# COUNTY COUNCIL'S RESPONSE TO CONSULTATION ON THE FOLLOWING DEVELOPMENT PROPOSAL

**Application No:** 19/01740/HYBRID-2

**Location:** Land Adj To Promised Land Farm, Wendlebury Road, Chesterton

**Response date:** 17<sup>th</sup> March 2020

JOB TITLE		CLIENT	
CATALYST BICESTER		ALBION LAND	
DRAWING TITLE			
WENDLEBURY ROAD FOOT/CYCLEPATH ENHANCEMENT WITH HEALTH AND RACQUETS CLUB			
SCALE	DRAWN BY	DATE	DRAWING No
1: 500@A1	RJM	03/05/19	19539-12-01
			REVISION
			B

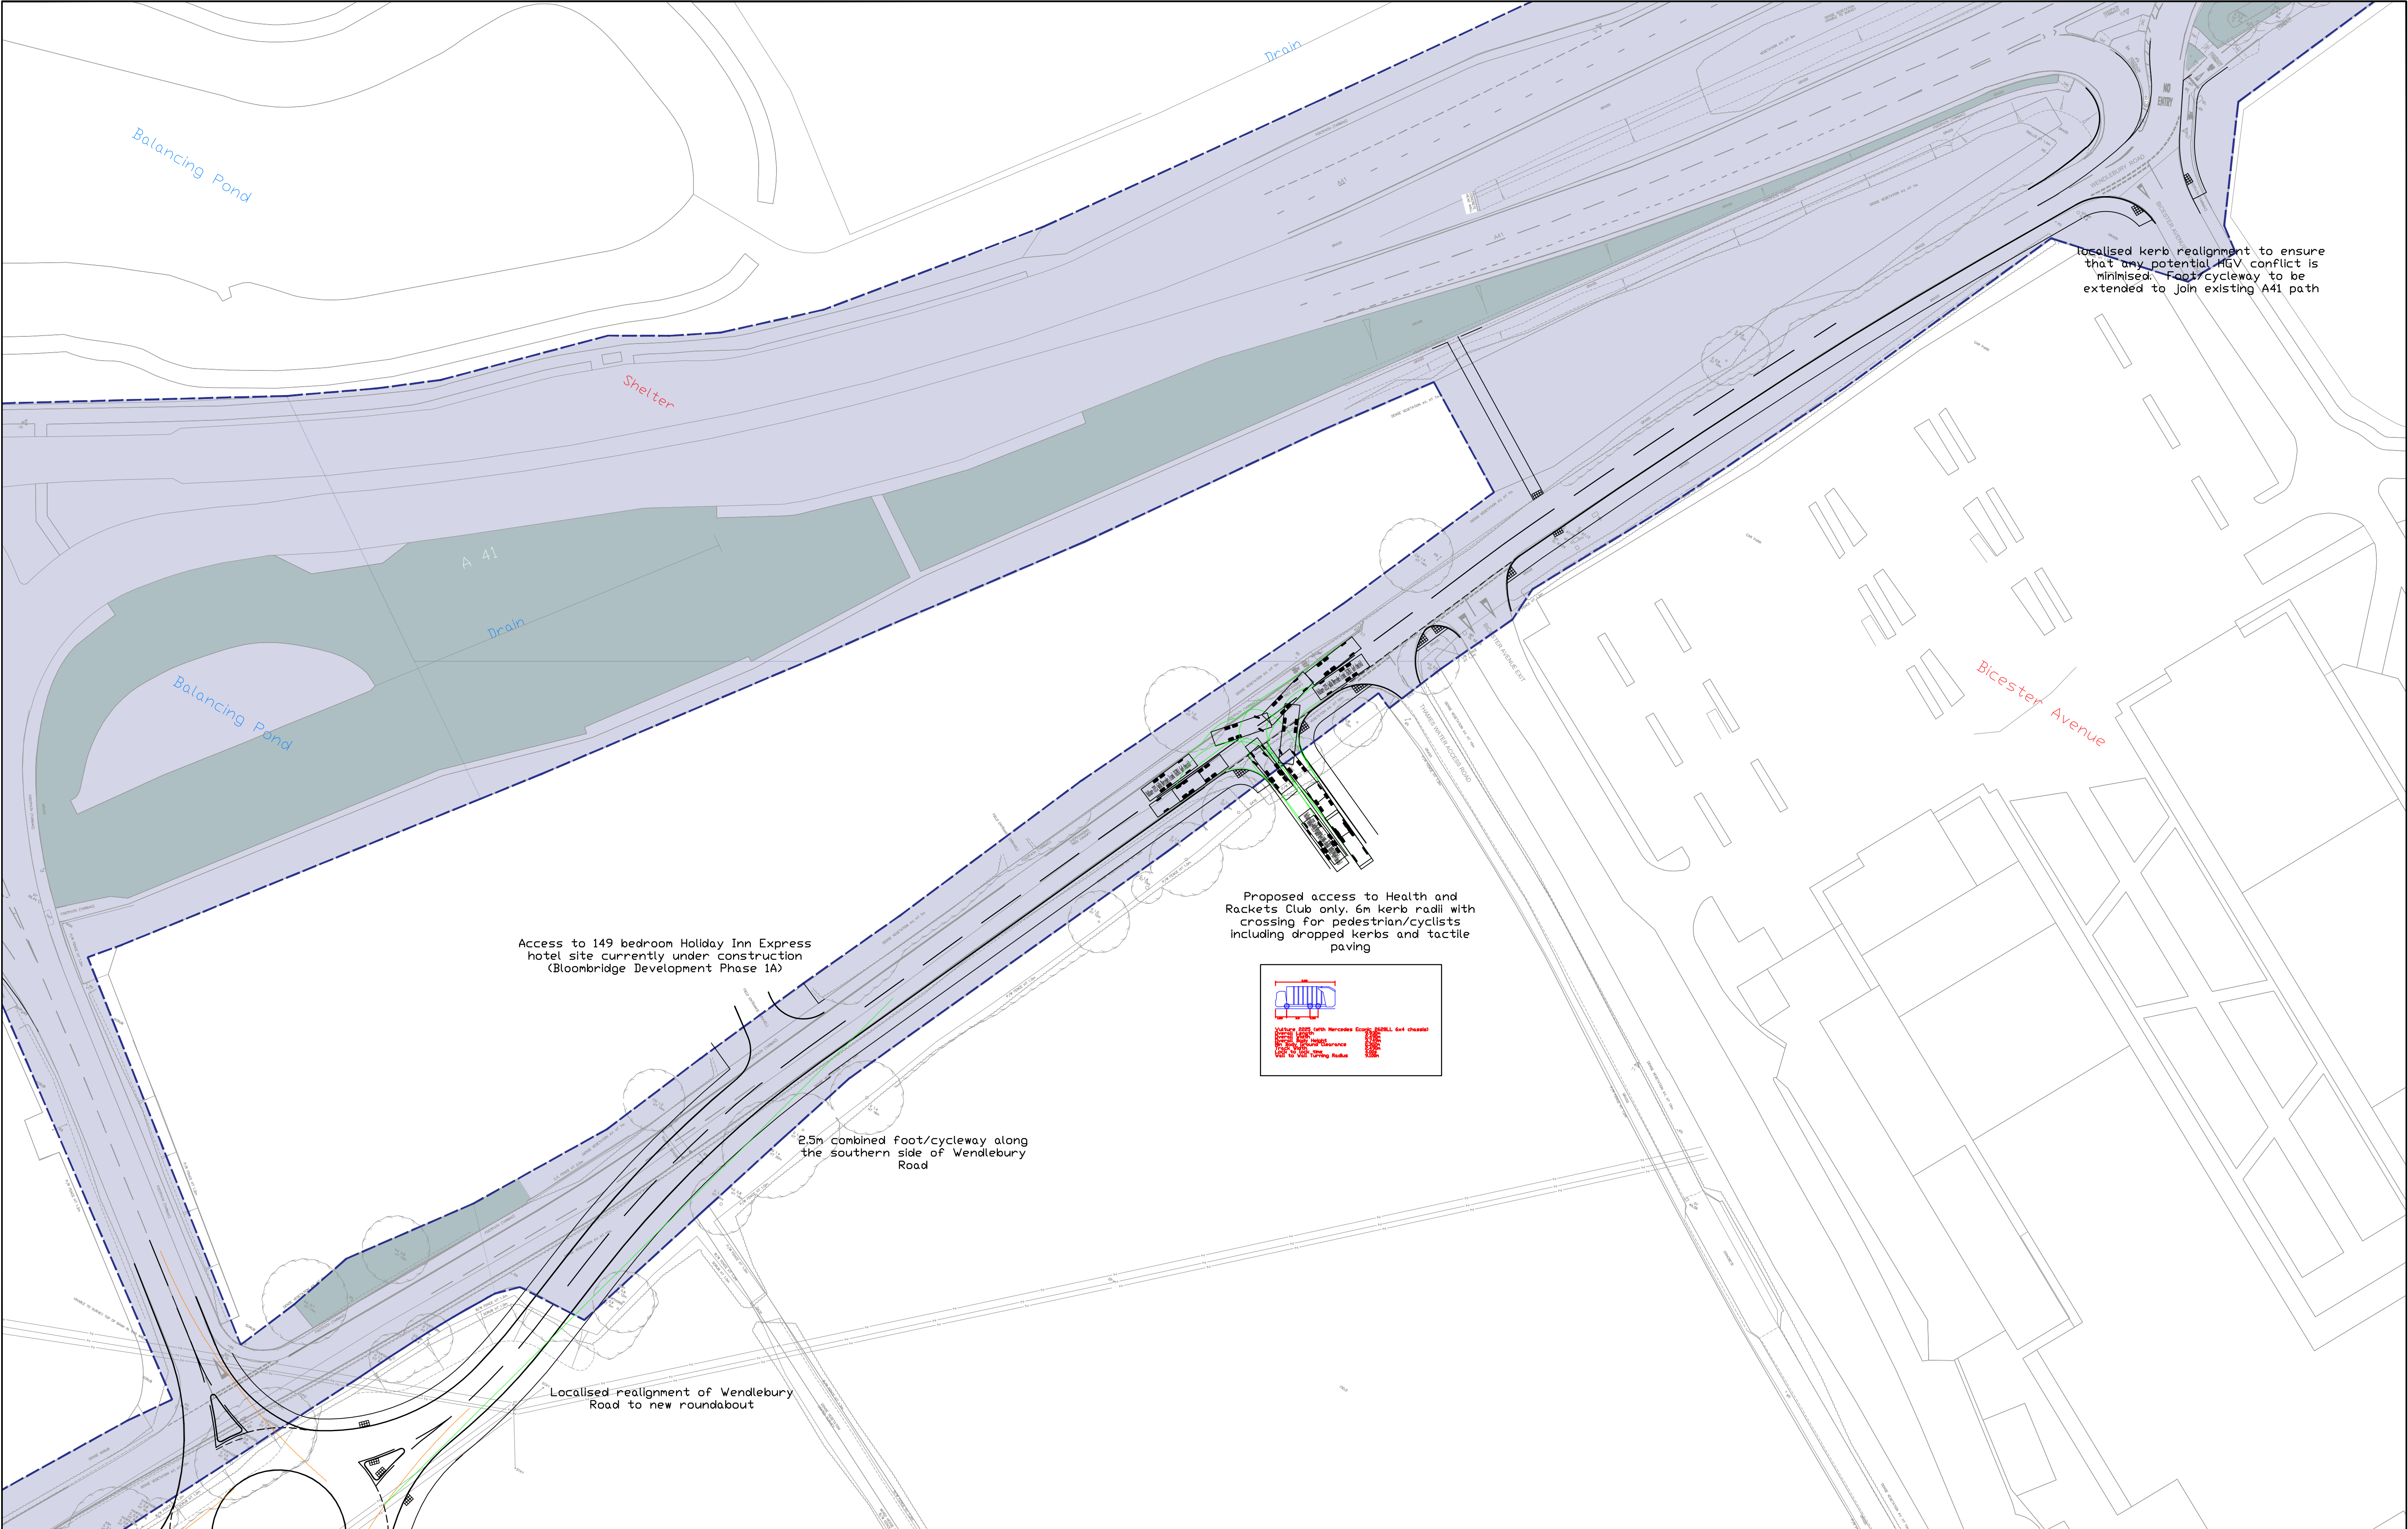
The applicant has submitted revised access arrangements (illustrated by the DTA Drwg Nos. 19539-16 and 19539-17). Notable with this arrangement are improvements to the existing pedestrian and cycling facilities to include a 3m shared use along the site frontage on Wendlebury Road right up to the A41/Pioneer Way junction toucan crossing. It is noted that a short section of this provision shall be constrained by land take where a 3m wide shared use could not be achievable. It is agreed that any narrowings along this has facility must be short and must not be less than 2.5m wide.

As part of the pedestrian/cycle improvements along Wendlebury Road the applicant has expressed a willingness to implement raised crossing treatments across accesses along Wendlebury Road. However, apart from the David Lloyds club access, the drawings do not indicate whether the other access points shall benefit from such a raised crossing for cyclists and pedestrians. Accesses to the Thames Water treatment facility and those serving the garden centre need to be clearly indicated that these shall have raised platforms including give-way markings on the approach from the side roads. This feature would give priority to pedestrian and cyclist crossing movements over side road vehicular traffic, making it more convenient to these sustainable travel users. In accordance with Oxfordshire Cycling Design Standards priority should be given to the cycle way across each of the access points. They would also benefit from vehicles approaching these access points at reduced speeds.

There is a footway being proposed along the development's northern boundary, which I assume is an access for pedestrians and cyclists into the Health and Racquets club and also wider employment site. My concern with this, lies in its termination with Wendlebury Road where it is not clear how the connection to the shared facility along

Wendlebury Road shall be achieved. The applicant must revise this arrangement to facilitate and improve connectivity in order to maximise walking and cycling links in accordance with the design principles of Policy Bicester 10 of The Cherwell Local Plan 2011 – 2031 and also in accordance with para 108 (b) of the revised NPPF.

JOB TITLE CATALYST BICESTER		CLIENT ALBION LAND	
DRAWING TITLE WENDLEBURY ROAD SITE ACCESS ROUNDABOUT			
SCALE 1: 500@A1	DRAWN BY RJM	DATE 03/05/19	DRAWING No 19539-12-02
REVISION B

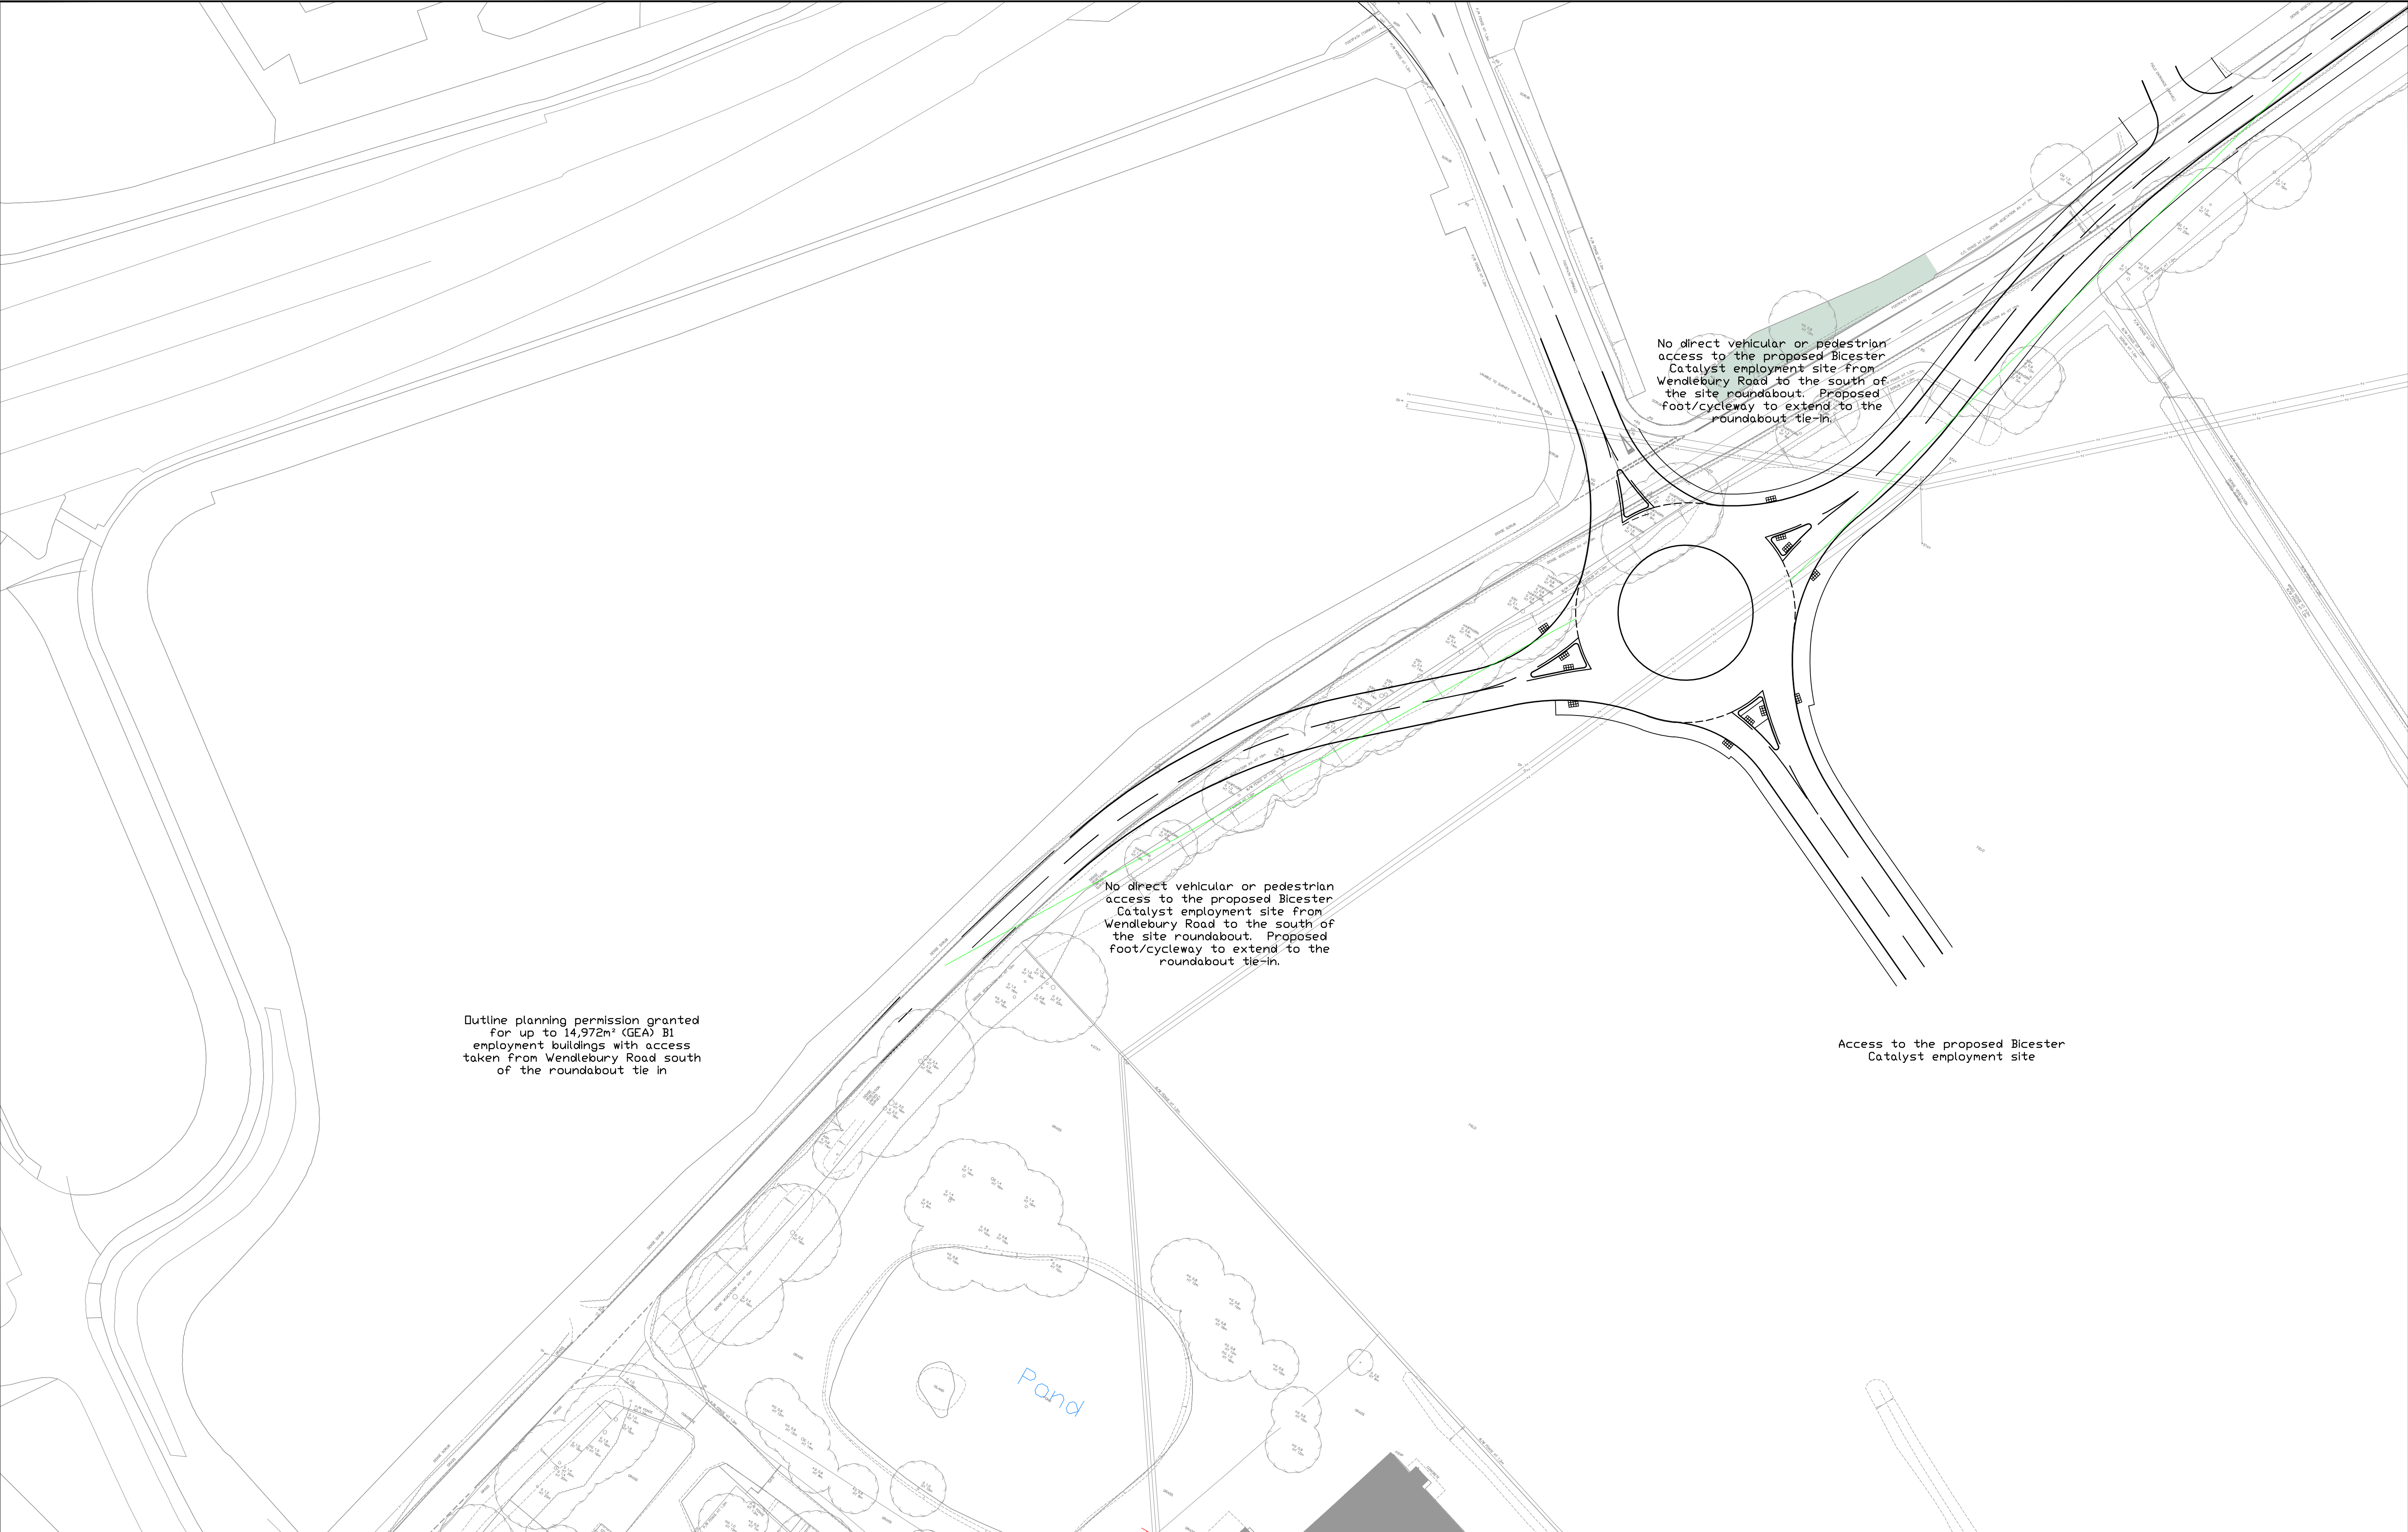
Access from the employment part of development is proposed off a new standard roundabout as a replacement of the consented mini roundabout in order to provide a

safe and suitable access to the Bicester 10 Phase 2 site. The new roundabout would serve the Wendlebury Road (North and South arms), site access and the Vendee Drive link road shall form the east and west arms respectively. This arrangement shall require the development to dedicate some of the land to highways in order to realign Wendlebury Road and also accommodate the new roundabout.

This roundabout design was a subject of initial consultations where it was considered an acceptable arrangement in terms of capacity and safety for those accessing or egressing the site. It has however been assessed against provisions of continuing pedestrian and cyclist movements in consideration that this is on Sustrans Route 5 where local and national cycling needs to be catered for.

The county council's adopted cycling design standards requires considerations to be made to new roundabouts within development. In order to slow traffic and also to give priority to cyclists, roundabout entries are required to be radial rather than tangential, a layout that encourages and maximises cycling and walking. There is the possibility that some additional land within the blue line might be required for the extent of the adoptable highway works. A more compact style roundabout has been recommended at this location. Should the applicant be agreeable to such a compact roundabout the Highway Authority's objection shall likely be removed.
